From: Alan Bawden <Alan.Bawden@rfs.nsw.gov.au>
Sent: Thursday, 27 June 2019 4:06 PM
To: Sheelagh Laguna
Subject: RE: Cairncross Landfill Expansion - SSD 5792. Attn: Alan Bawden

From: Sheelagh Laguna <Sheelagh.Laguna@planning.nsw.gov.au>
Sent: Wednesday, 19 June 2019 2:18 PM
To: Records <Records@rfs.nsw.gov.au>
Cc: Bruce Zhang <Bruce.Zhang@planning.nsw.gov.au>
Subject: Cairncross Landfill Expansion - SSD 5792. Attn: Alan Bawden

Attached is supplementary information provided by the Applicant dated 9 May 2019 in response to your letter of 13 March 2019.

**Figure 1-14: Stage 2 & 3 Boundary Typical Cross Section**

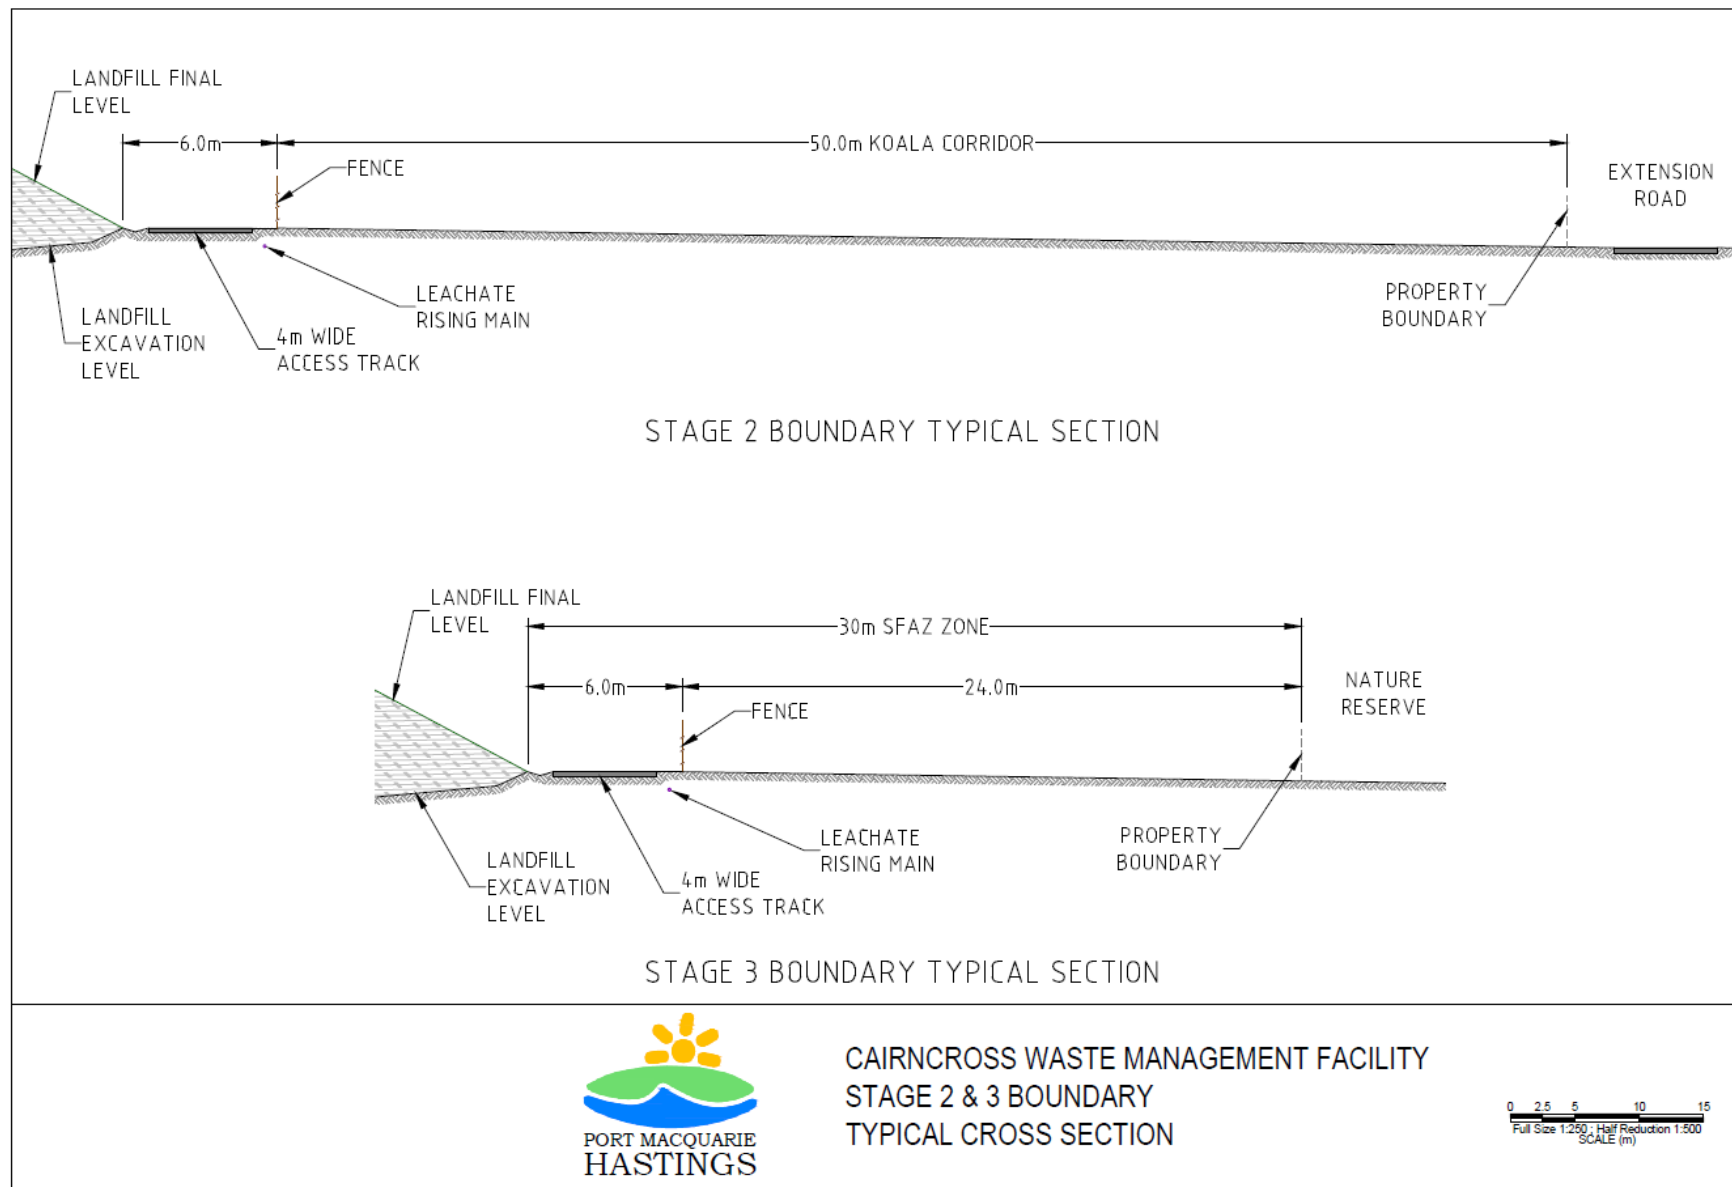
A trafficable defensible space is to be provided around the operational stage(s) of the facility to be managed as a 10m inner protection area (IPA)

I telephoned the consultant and discussed their response and they confirmed that a 10 metre IPA can be achieved alongside of 6 metre trafficable defensible space.

Therefore no changes to the NSW RFS recommendations.
